Dear Michael,

Thank you for consulting us on this reserved matters application.

The drainage strategy submitted states that it is intended for a reserved matters application and to discharge conditions. We do not support an application to discharge conditions as part of this reserved matters application. The level of information supplied is insufficient to discharge the conditions.

Infiltration Report

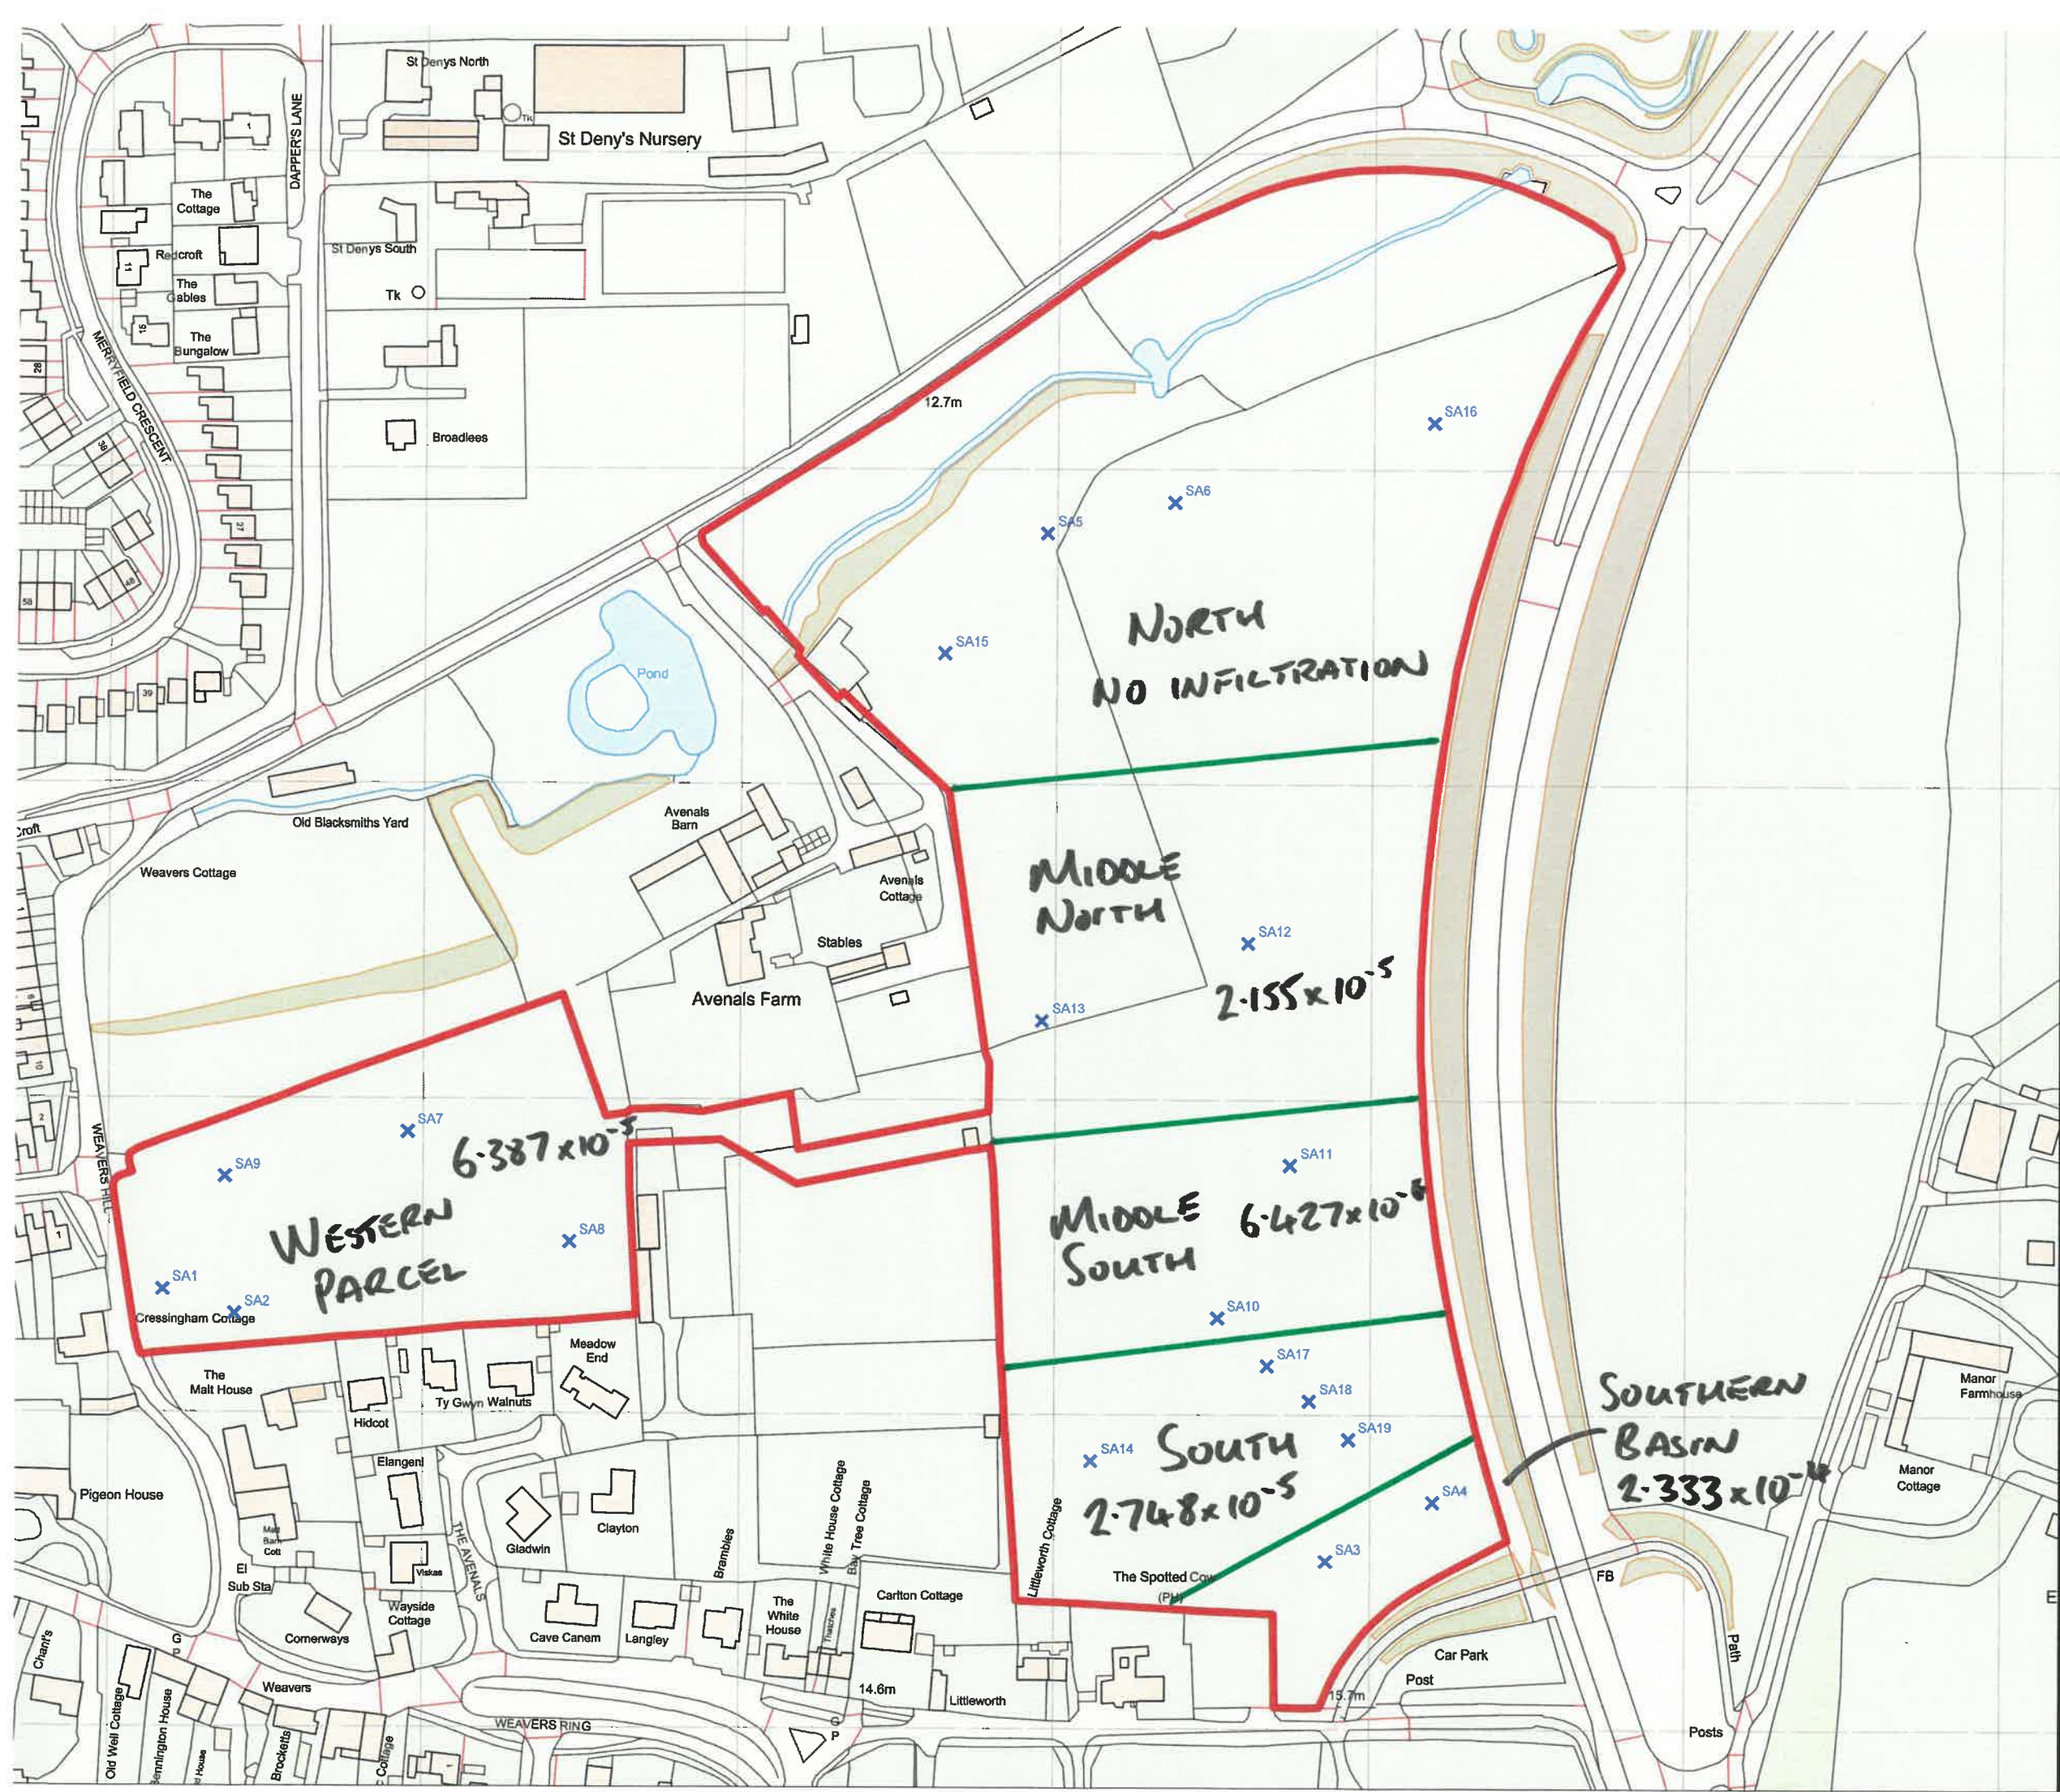
9. Please remove the proposed trees from within basin extents, especially the attenuation basin.
10. A plan is required showing that a clear 3m buffer is provided around all attenuation and infiltration basins to facilitate future maintenance.
